Please treat as additional and substitute

DRAWING TITLE
SOAKAWAY DESIGN ALTERNATIVE TO PERMEABLE PAVED INFILTRATION SYSTEM

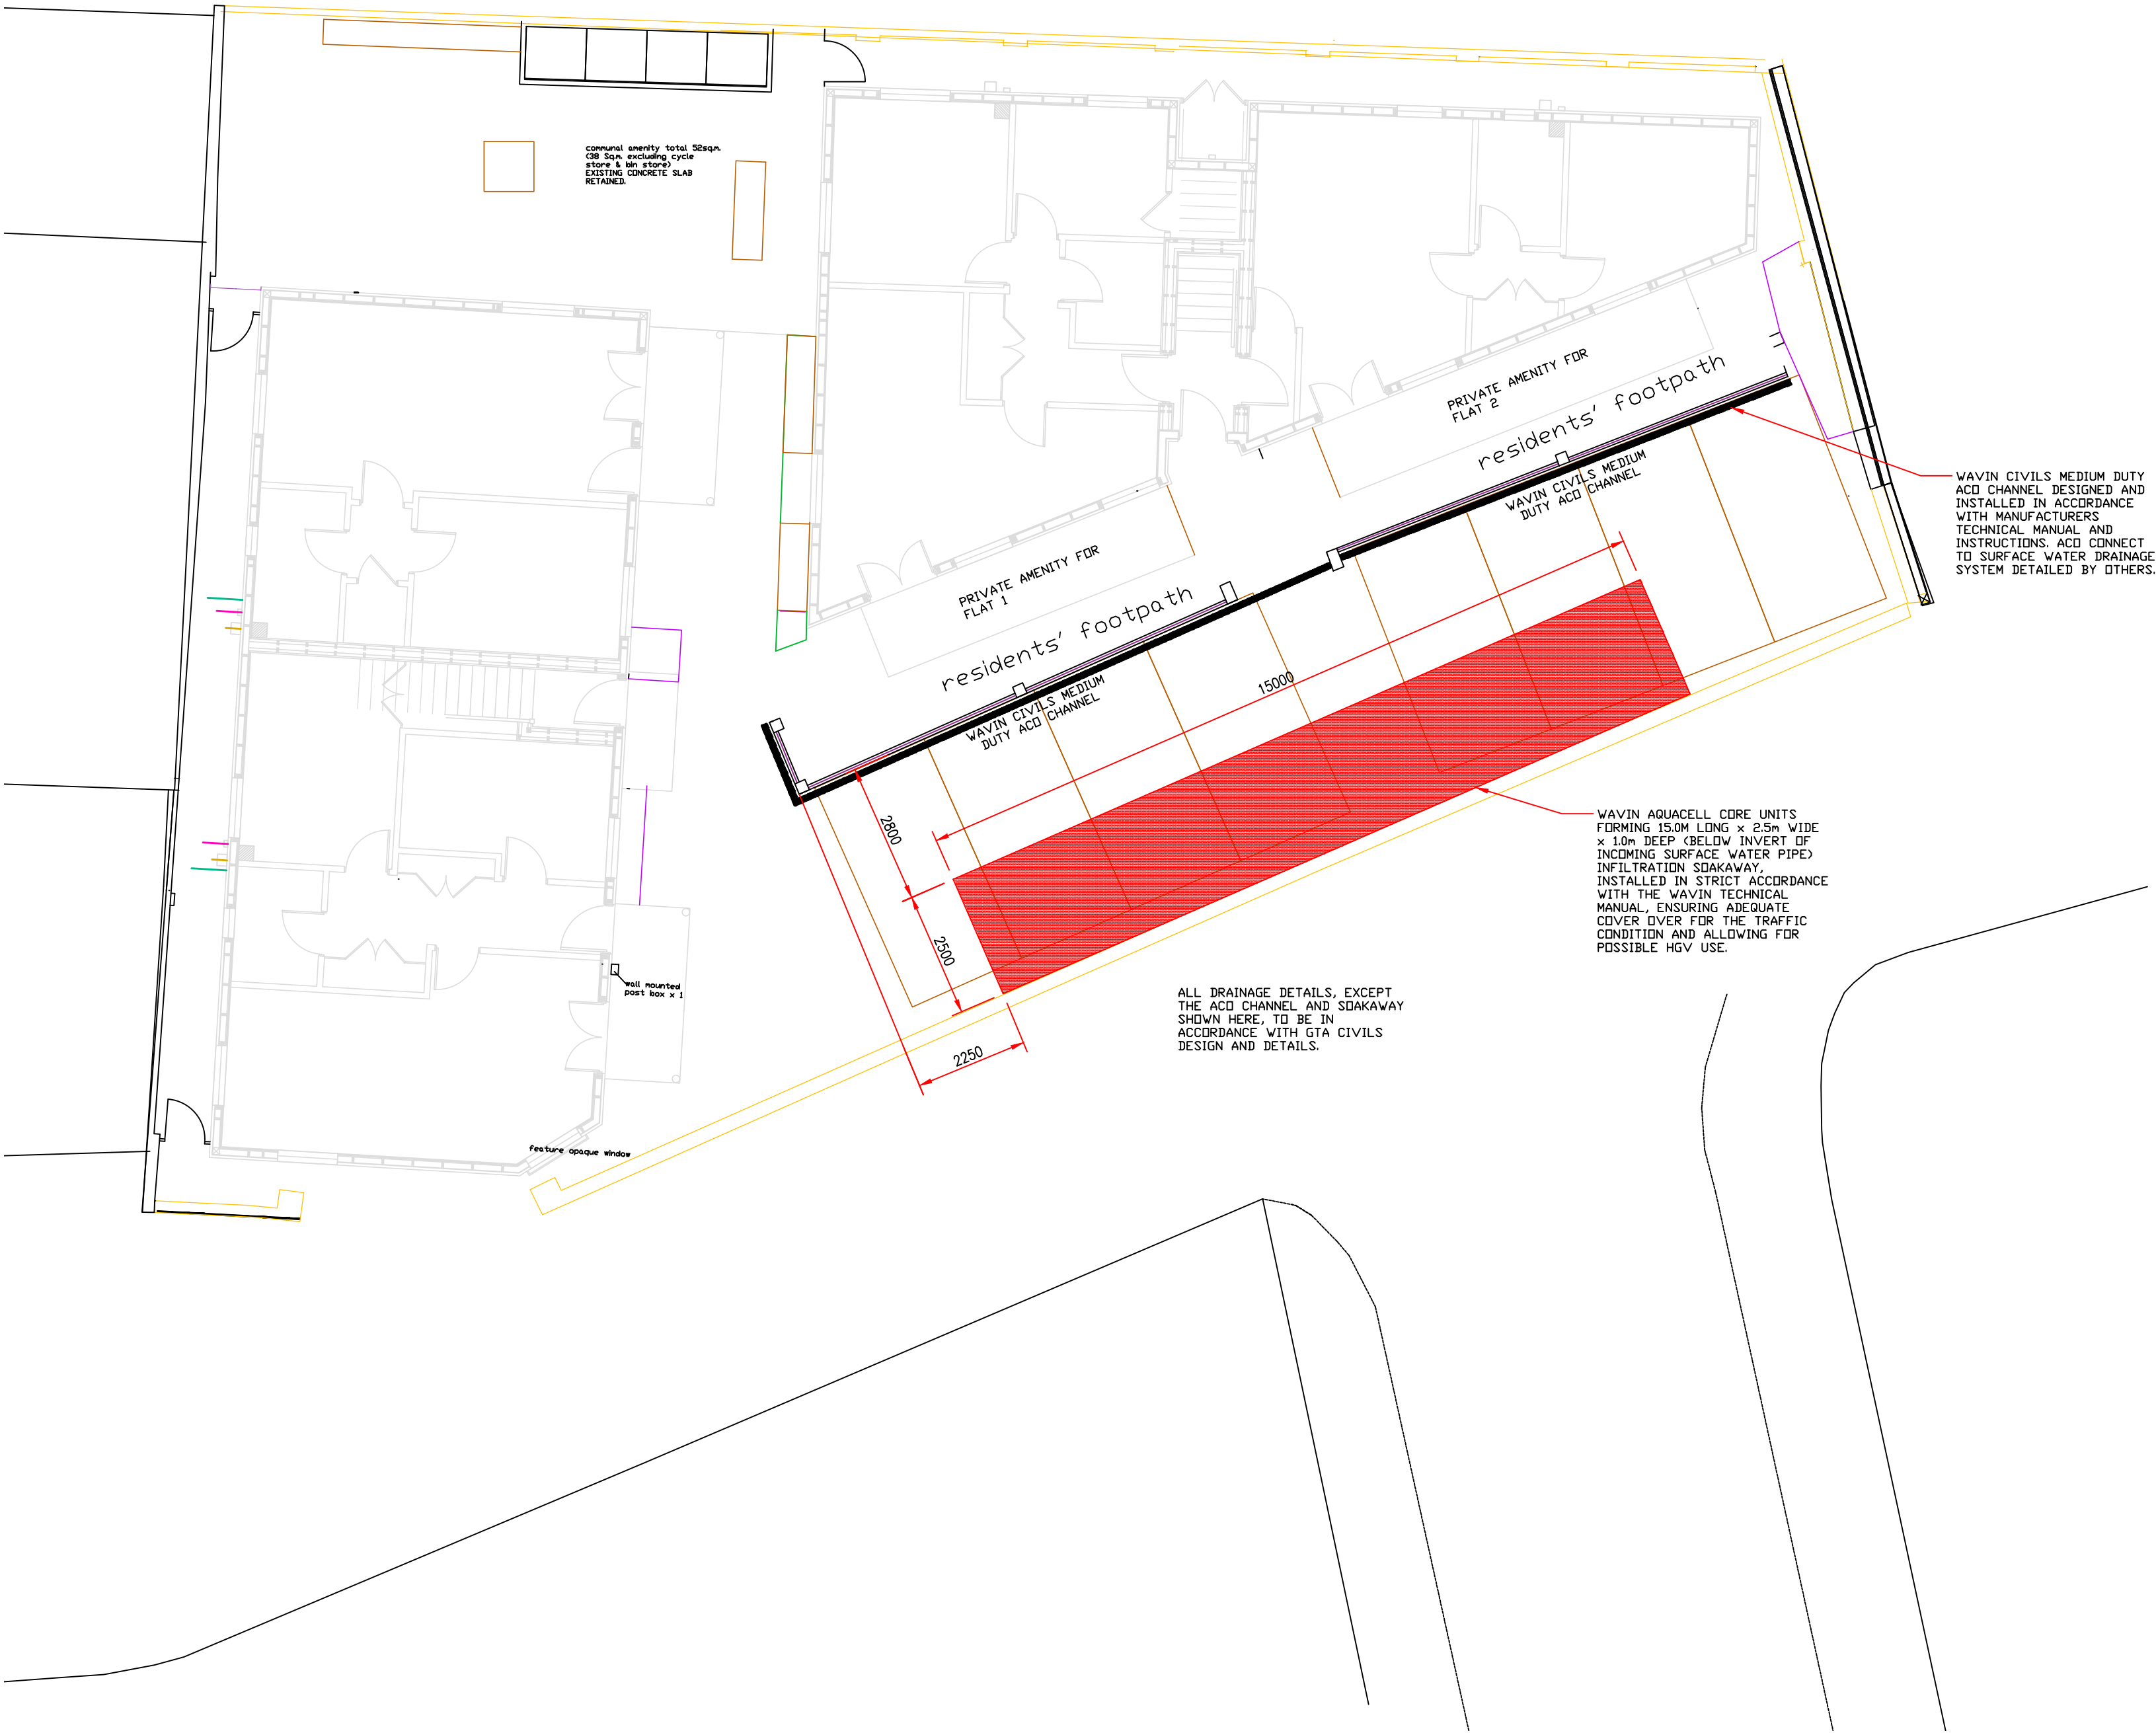
1. Please provide details of infiltration testing and groundwater monitoring. Including the depth that the infiltration tests were completed to. The proposed soakaway is deeper than the agreed permeable paving.
2. Please submit drawing details for the soakaway and ACO channel, including the appropriate cover depths and levels.
3. Please include the location of pipes and manholes on the Drainage Layout, please label these with their diameters, materials, cover levels, invert levels and falls as appropriate.
4. The calculations have confused the dimensions of the soakaway. The depth is 1m (1000mm) rather than 14776mm. Please adjust accordingly.
5. Please add 40% allowance for climate change.
6. Please provide silt traps upstream of the connection to the soakaway and show these on the drainage layout.

Please find attached revised drainage design, calculations, drainage report and manufacturer's details for silt traps as requested.
